City of Albuquerque Stormwater Construction Site Inspection Report

ESC File No.	A11E0111	Project Name:	McMahon Lots		
NPDES Id. No.	NMR1002NB	Location:	5710 McMahon Blvd		
3/10/2021	Owner	Contractor			
Operator	JMD-McMahon, LLC	Wilger			
Contact name & title	Doug Peterson	Don Wilger			
e-mail	doug@petersonproperties.net	don@wilger.com			
Contact Phone #	858-1500				
COA Inspector	Doug Hughes	Start/End Time:	10am		
Construction Phase:	infrastructure nearly complete				
Type of Inspection:	Regular	Storm Event	Post Storm Event >0.25"	311/Complaint	Follow Up
Weather at time of inspection?	Clear	Temperature: ~	45		
Estimated date of last storm 0.25" or greater	2/22/2021

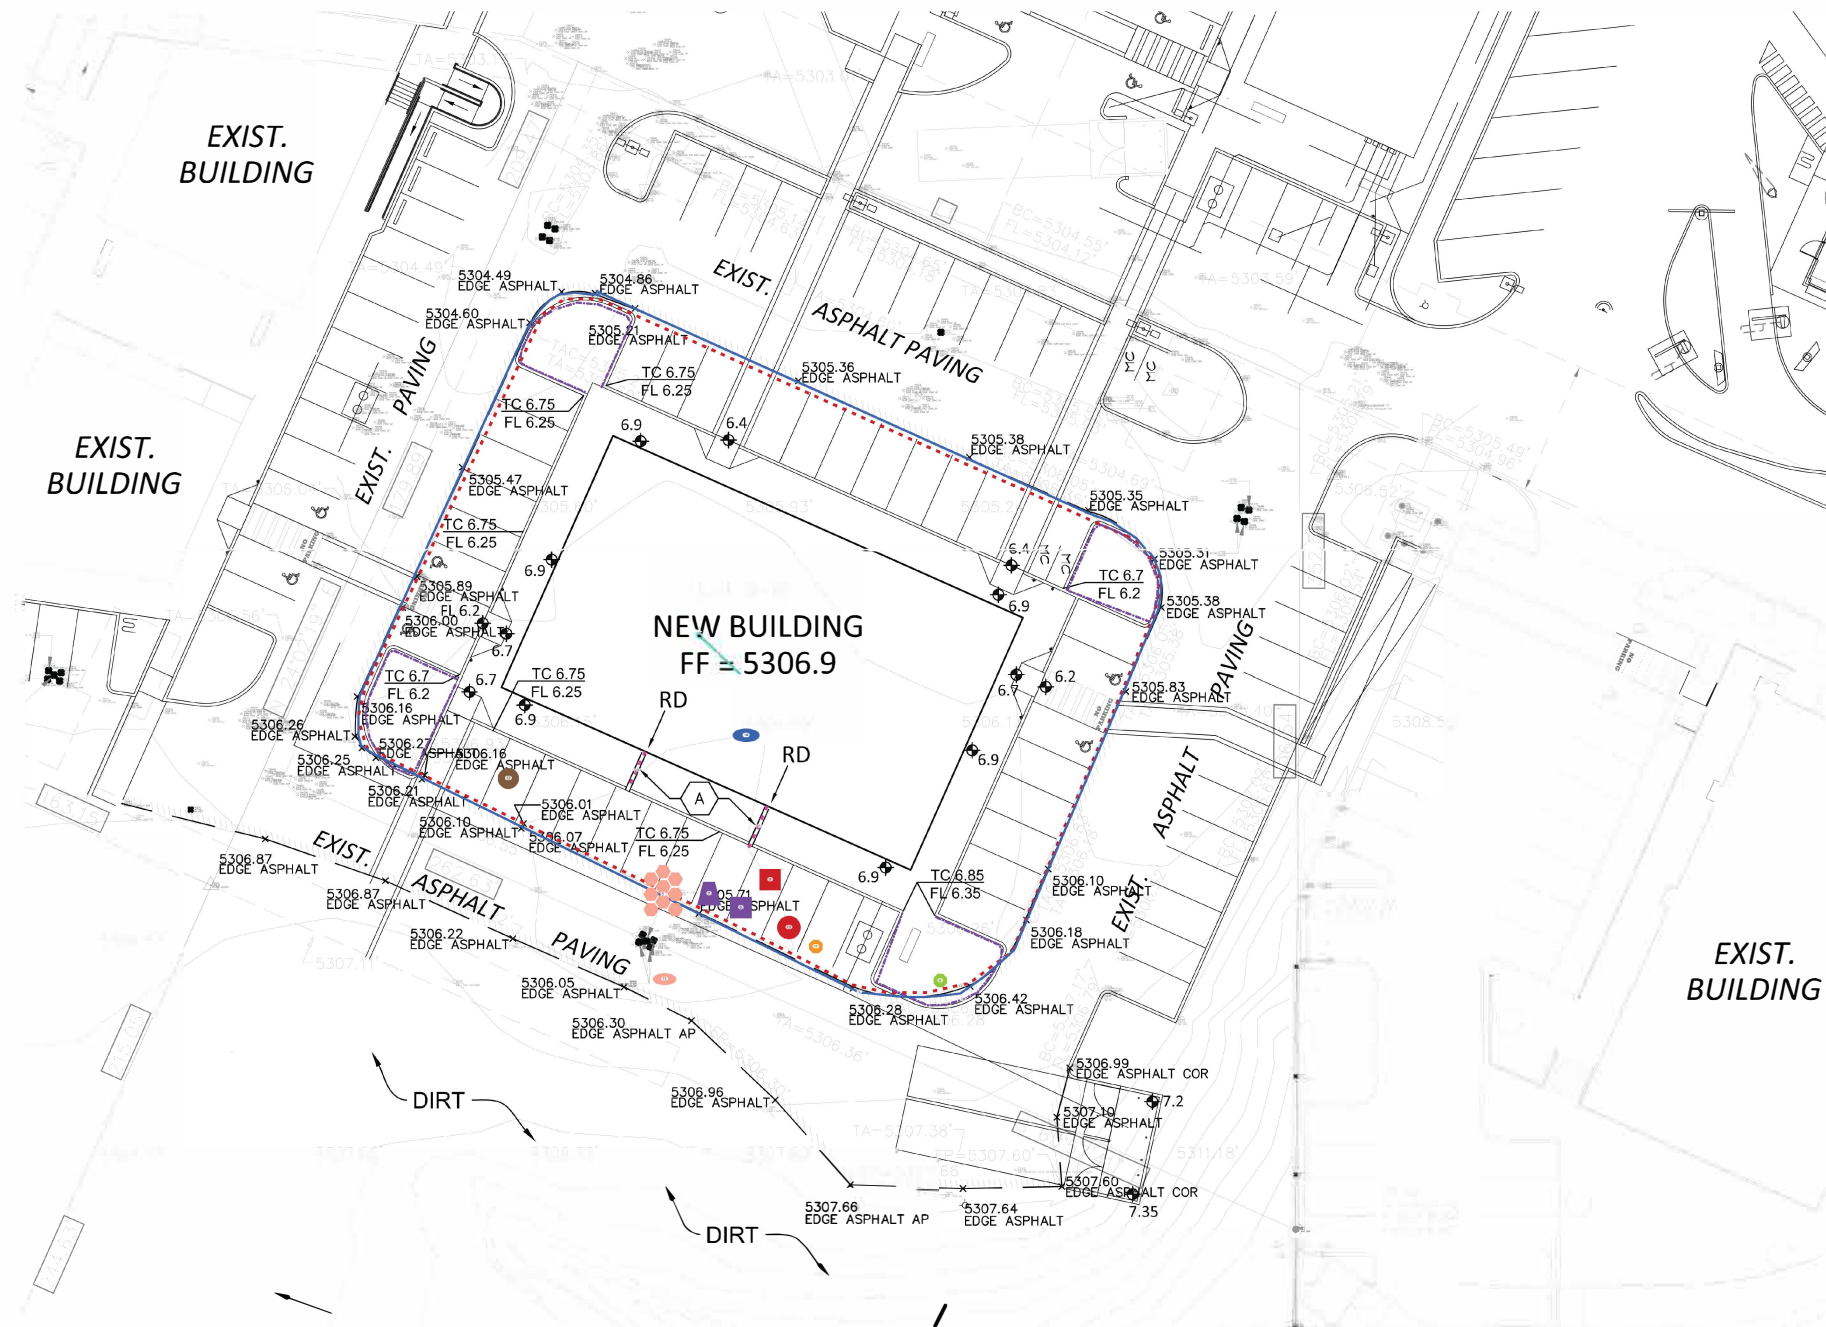
Item Number	Deficiency/ Corrective Action				
1	The NPDES coverage needs posted. The SWPPP location must also be identified on the sign.				
2	Sediment in the parking lot needs removed.				
3	Silt fence most OK. Additional fence should be added around center dirt island & BMP controls should be updated on SWPPP map.				
4	Stabilization missing. The site needs to be stabilized per CGP2.2.14. Inspections and BMP maintenance must continue until all areas of land disturbance are stabilized.				
5	***Please provide the latest SWPPP self-inspection report.

Notes:	
Stabilization per 2.2.14 is needed on all areas at grade.	
Seed and mulch should happen soon to correspond with the growing season.	
Rock mulch is recommended if Irrigation is not available.	
Keep sediment out of adjacent parking lot.
